CITY OF ALBUQUERQUE

March 16, 2021

**Re: Trails Tract 1 Multi-Family Development
Traffic Impact Study, Draft
HT#C09D015, Dated March 2021**

After review of the draft Trails Tract 1 Multi-Family Development Traffic Impact Study dated March 2021 the City's Planning Transportation Development Review has the following comments and corrections.

TRAILS TRACT 1
EXISTING & PROJECTED TURNING MOVEMENTS

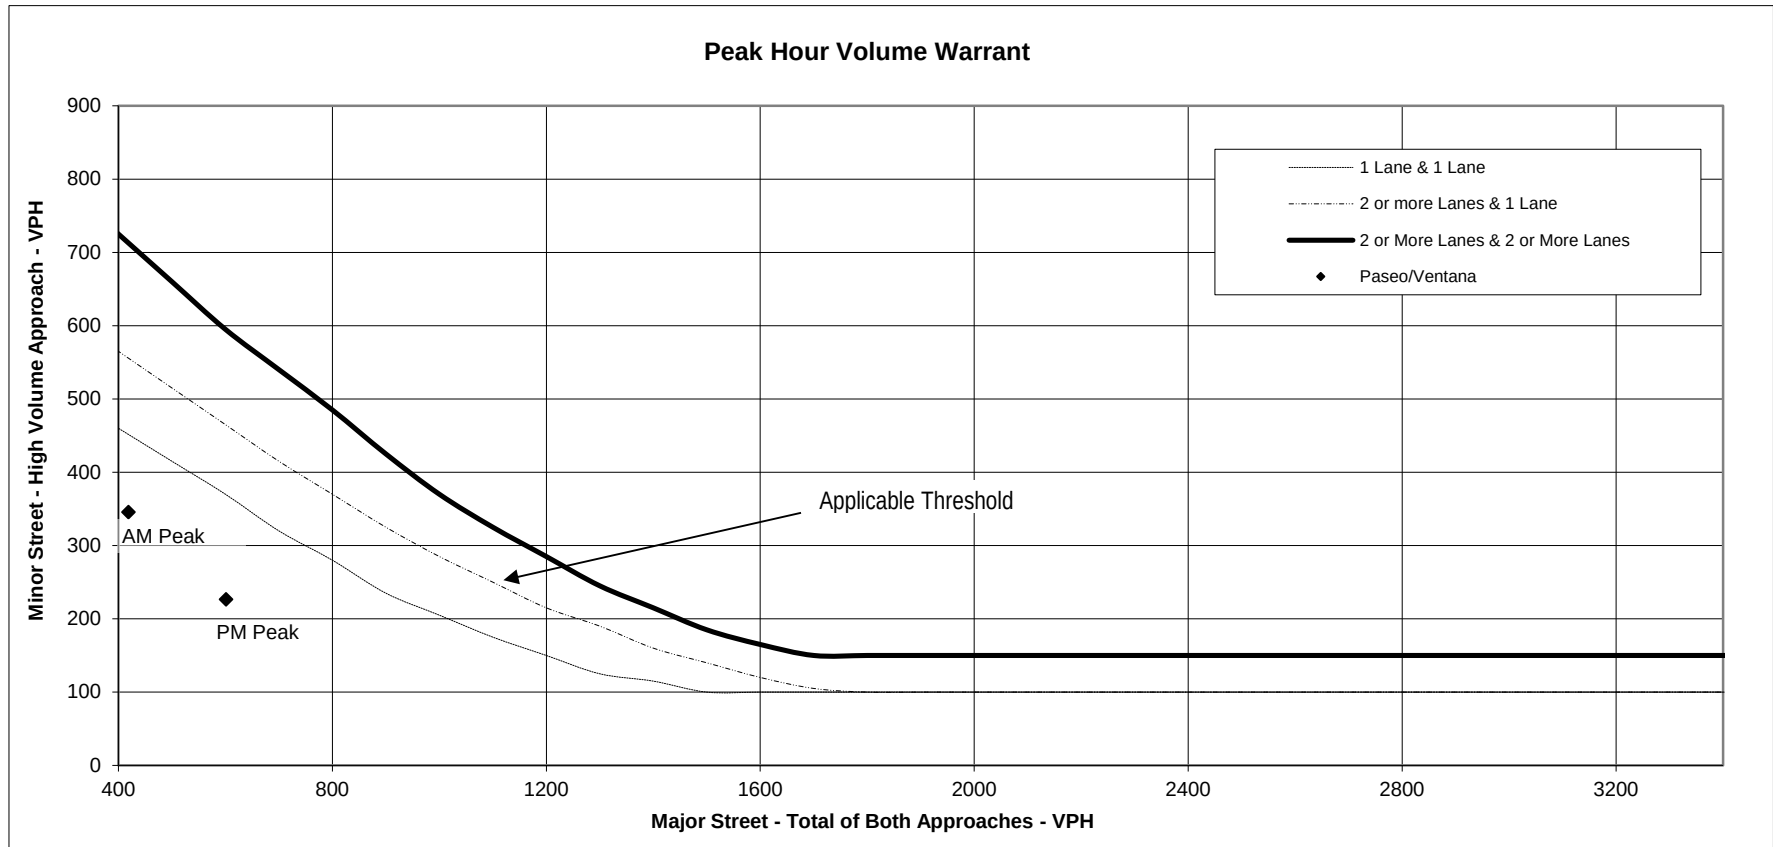
1. In the appendix Existing and Projected Turning Movements table;
 - a. Correct the northbound street to be Woodmont, see attached.
2. Provide the right and left turn lane length based on queue storage or deceleration length requirements including the transition type/size.
 - a. Northbound Woodmont at Paseo del Norte right turn lane, resulting from the development
 - b. Westbound Paseo del Norte at Woodmont left turn lane, resulting from the development
 - c. Eastbound Paseo del Norte at Woodmont/Ventana West Pkw left turn lane, due to existing and future traffic not development related.
3. In the Executive Summary on page 3 recommendations and page 21 recommendations describe the turn lane requirements to include queue storage or deceleration length whichever is greater.
